**Consultation Response from KC,  
Lead Local Flood Authority**

**2023/93539 Land adj, Ledgard Bridge Mill, Back Station Road, Mirfield, WF14 8NZ**

**Date Responded: 10<sup>th</sup> January 2025**

**Responding Ref: 3**

Car Park Plan (part) 1: 200

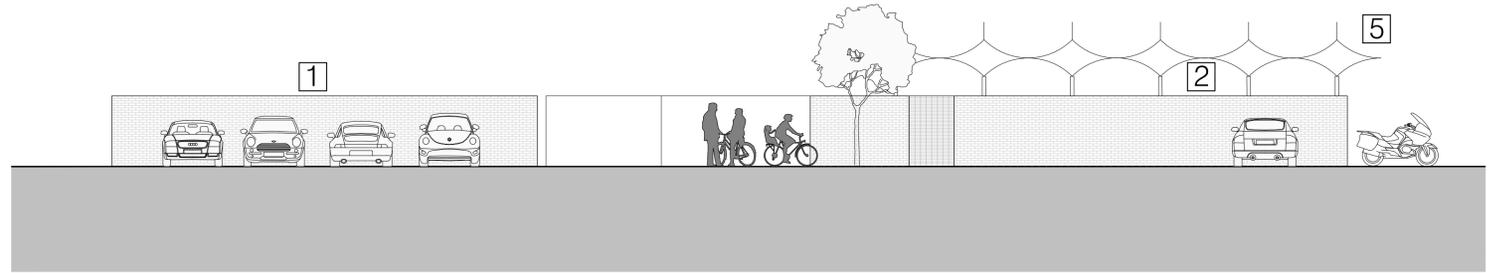
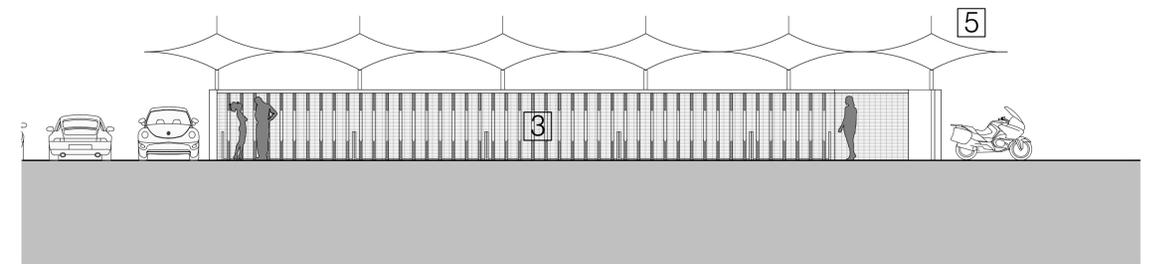
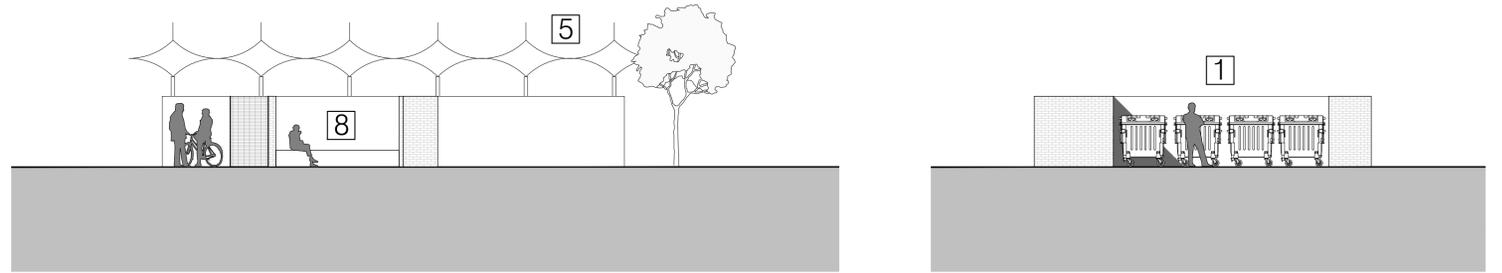
**Car Parking** areas are located in flood zone 3 and we cannot see any assessment regarding flood risk associated with this aspect of the development.

It is not recommended that a flooding in parking areas is above 300mm, should the sequential test be passed, and sequential approach relaxed for this site. We advise the planning officer to ask the Environment Agency to comment on car parking and potential floating of cars that could cause obstructions at within and beyond the site, i.e. at bridges, increasing flood risk elsewhere.
